**UPDATE OF LIST OF PLANNING APPLICATIONS TO BE DECIDED BY  
PLANNING SUB-COMMITTEE (HEAVY WOOLLEN AREA)**

**Planning Application 2023/92079**

**Outline application for erection of residential development of 10 dwellings, demolition of existing extension at 27 Moor Lane, widening of existing access and realignment of boundary walls**

**Rear of 23 to 43 Moor Lane, Gomersal, Cleckheaton, BD19 4LF**

Access Road Eastern Elevation (towards 25 Moor Lane) as proposed 1: 100

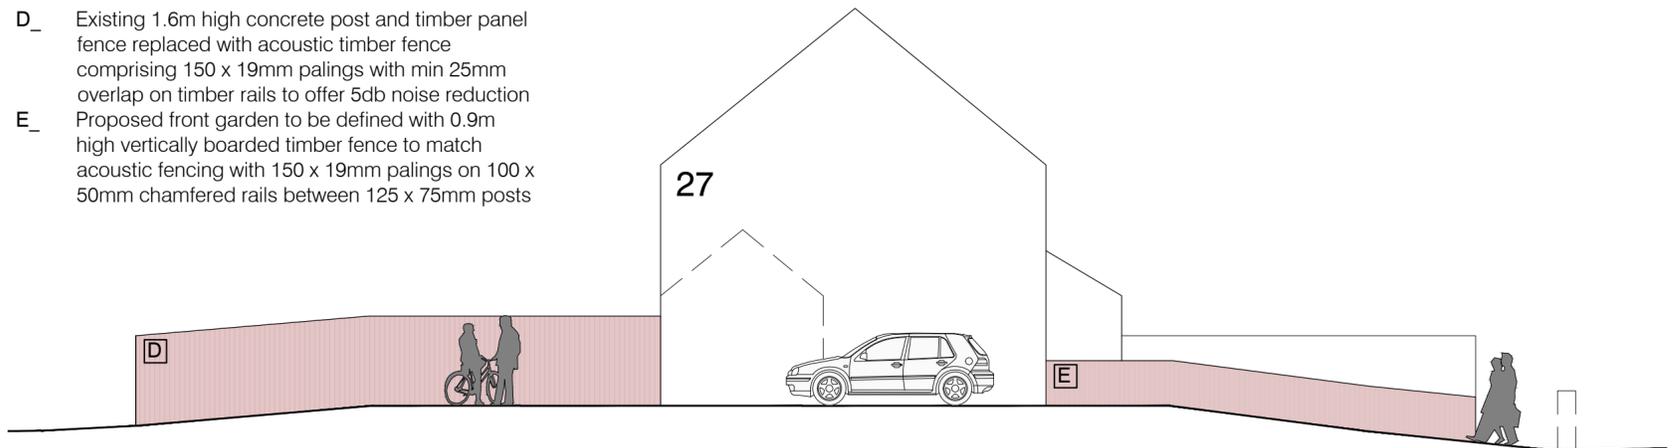
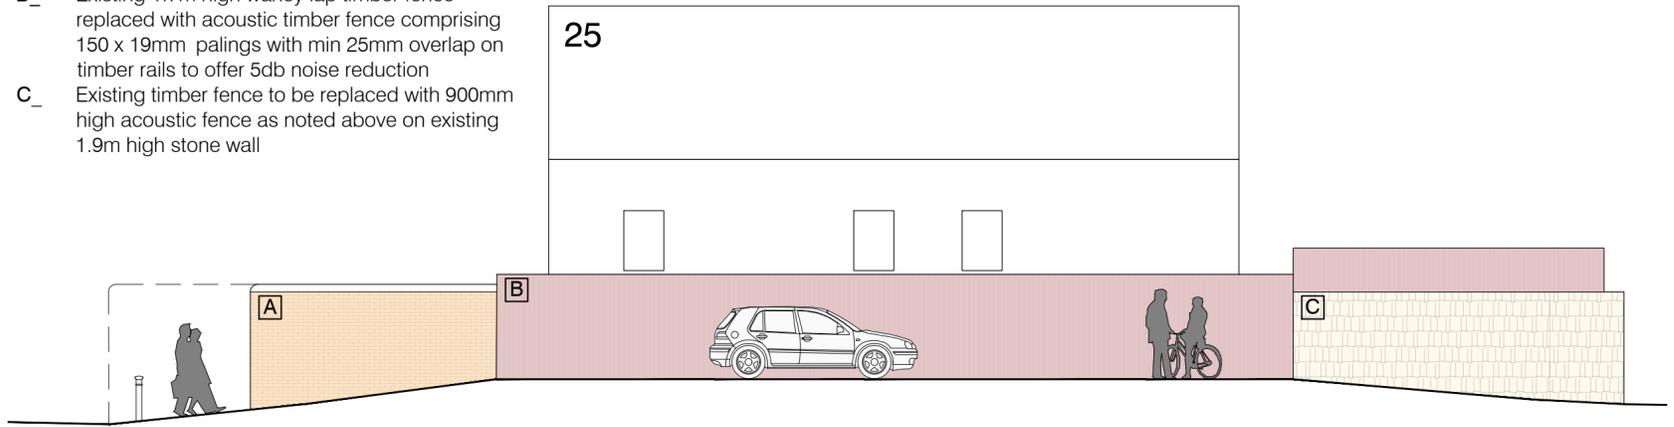
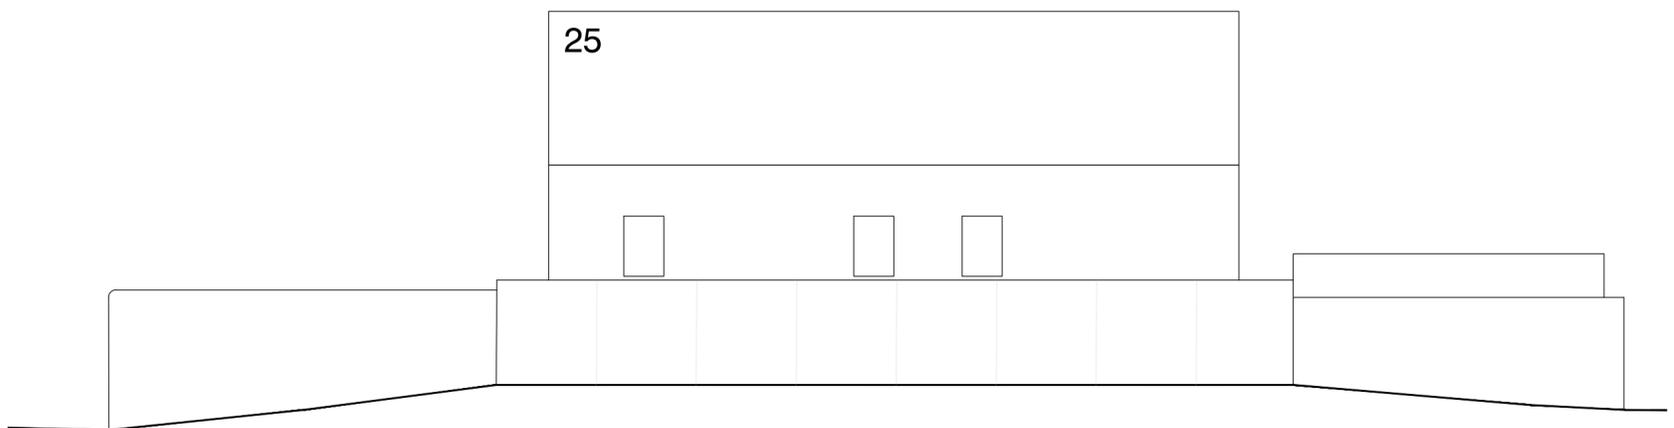
Regarding condition 24 which relates to the acoustic fencing, Officers would also request details of the appearance of fencing in the interest of visual amenity.
